Re: Planning Application 19/0350

Address: Higher Boyce Farm Stoneygate Lane Ribchester PR3 3YN

Simon Hardie
Highways Development Control
Lancashire County Council

Proposed Site Plan
Scale 1:500

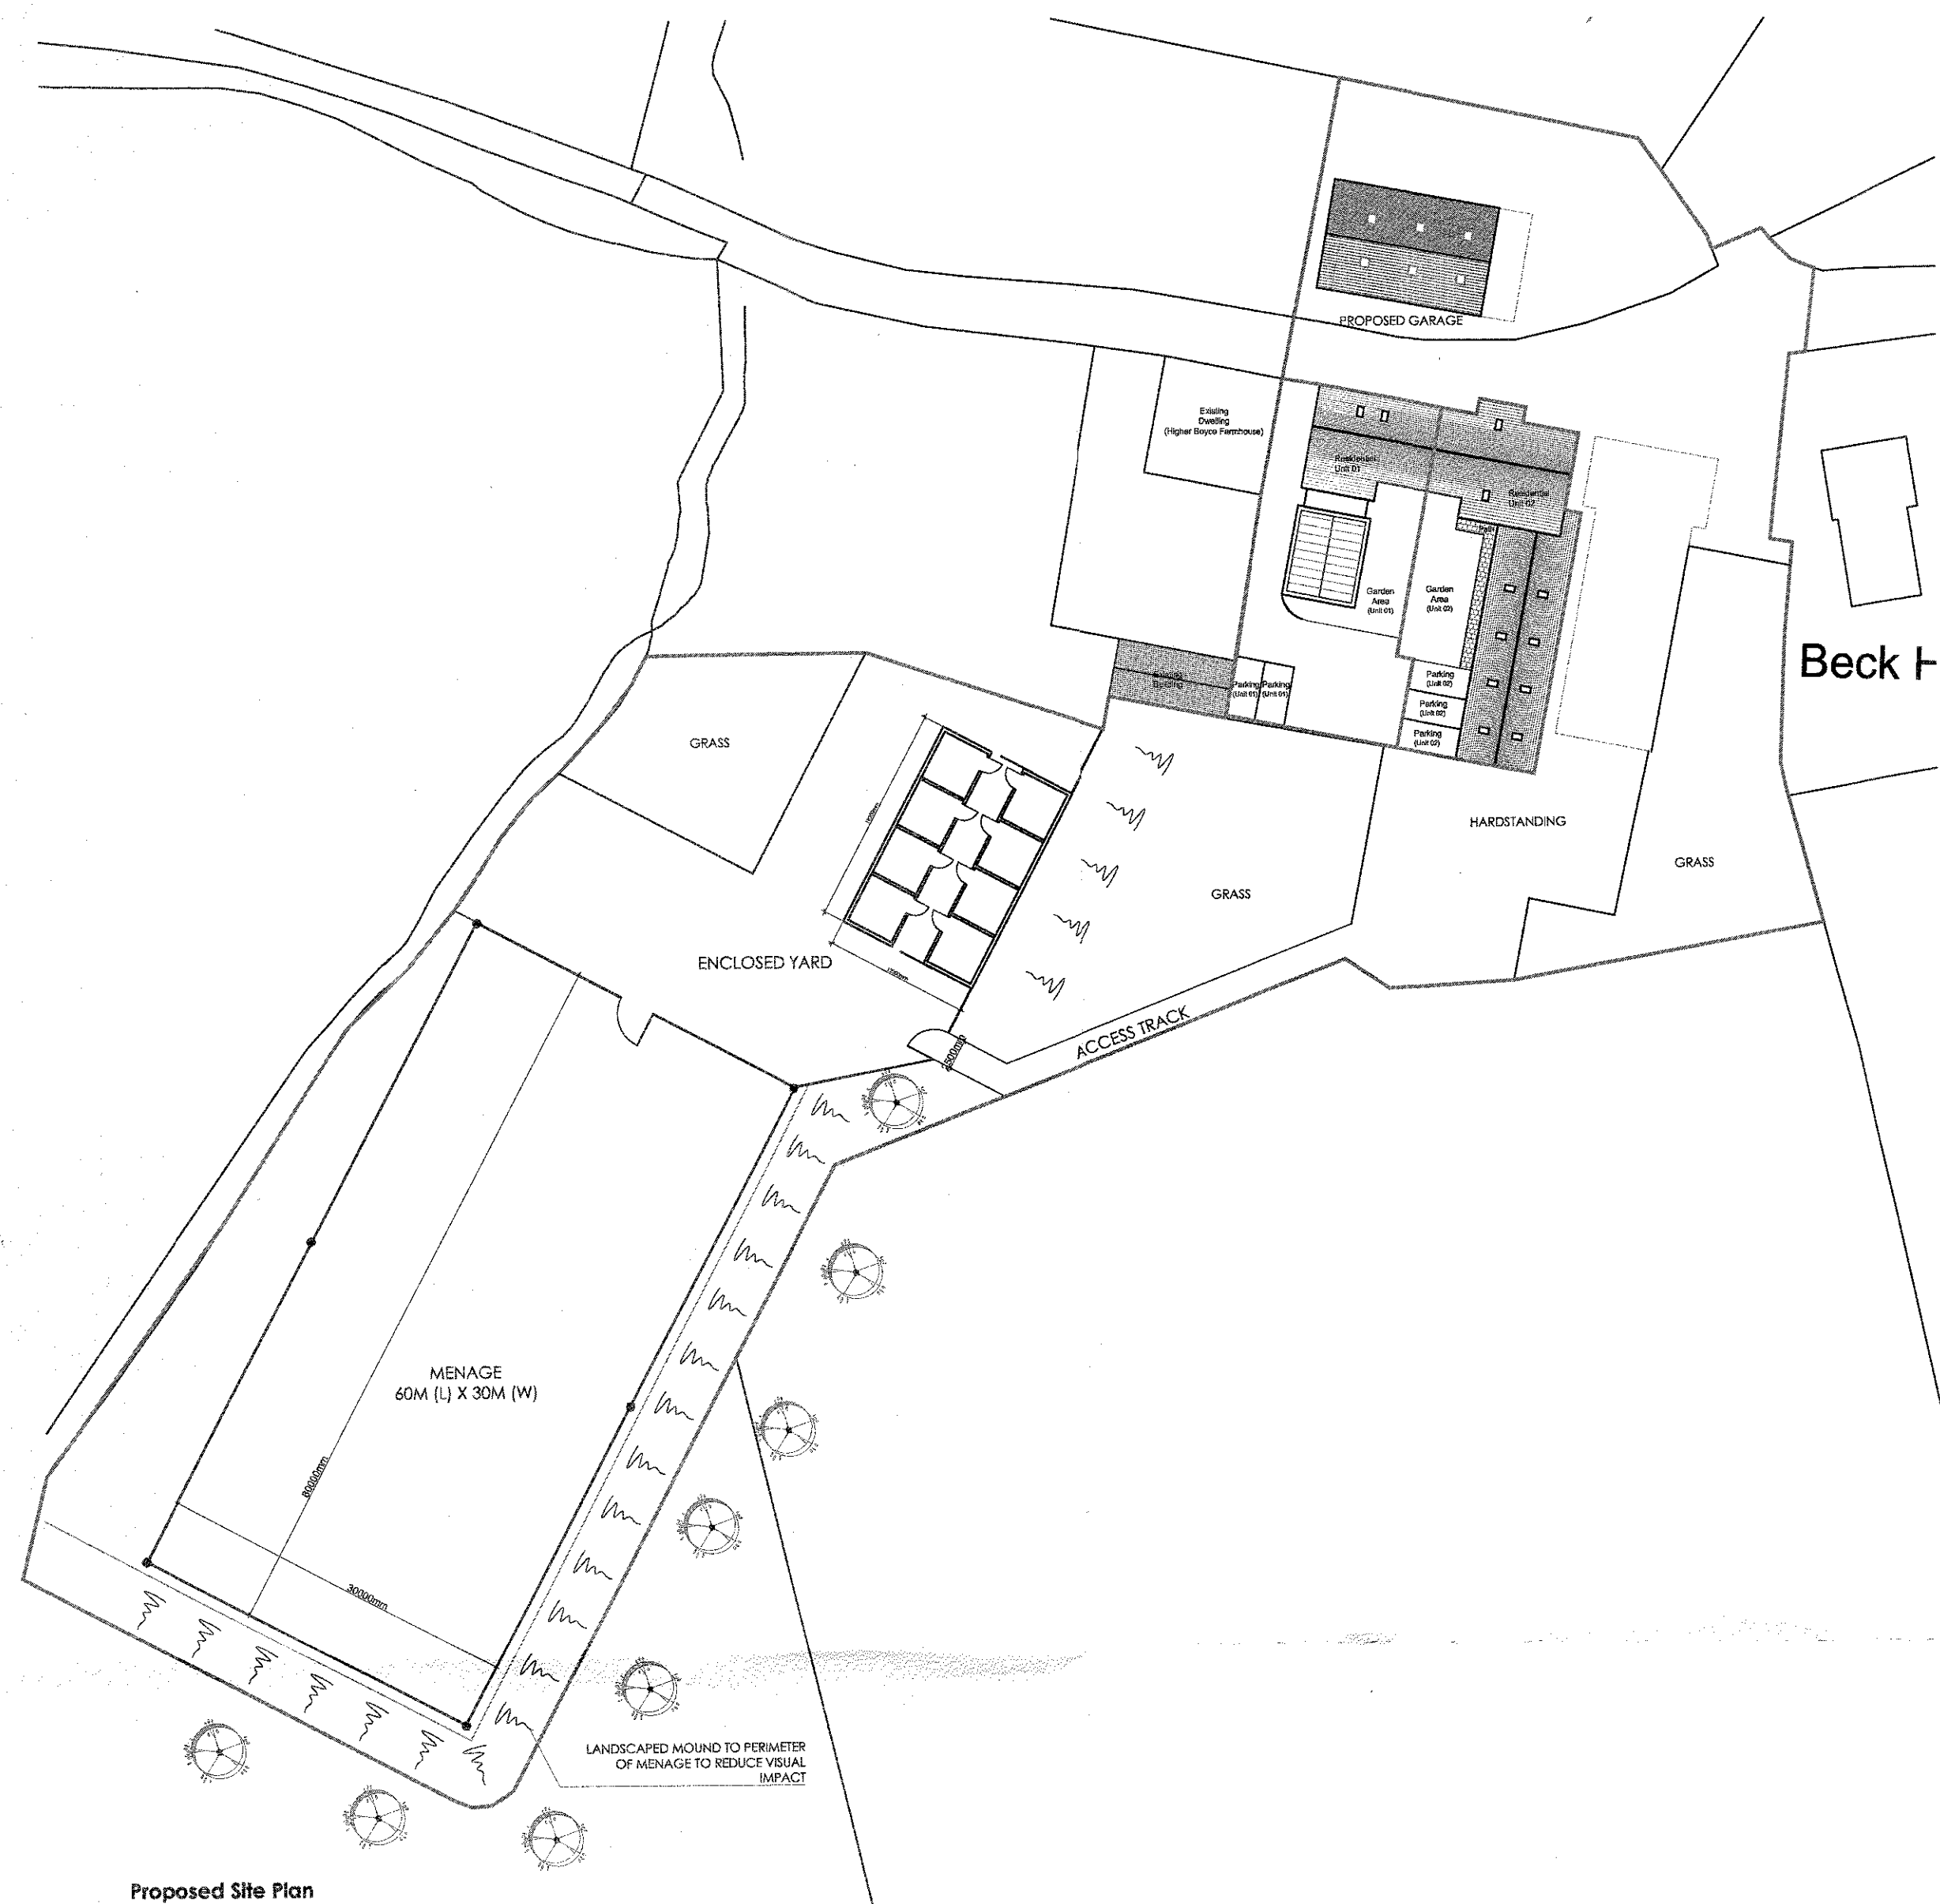
These centre on the access from Stoneygate Lane and the operational function of the stabling and manège. It is not expected that the stabling will be run as a commercial enterprise.

Previous Highway comments referring to the same site (3/2016/0177) made reference to the widening of the cattle grid and the provision of a suitable passing place. These earlier comments do not appear to have been addressed in this application.

The application also seems to include the building of a stable block to accommodate a possible 8 horses. It is expected that this will be conditioned to the use of the household.

In order to fully support the application we would look for further plans showing how our concerns regarding the access can be addressed, and we would wish for the following conditions to be added to the application.

1. Notwithstanding the provision of the Town and Country Planning (Use Classes) order 1987 paragraph 3(1) or any provision equivalent to this in any statutory instrument revoking and re-enacting this Order. The use of the stable, tack room and ménage be restricted to domestic use only as applied for unless the prior consent of the local Planning Authority is obtained and commercial livery, Equestrian events or other such use is prohibited.
Reasons: So that the Local Planning Authority can retain control over the impact of the development on residential amenity and/or highway safety in accordance with policy.
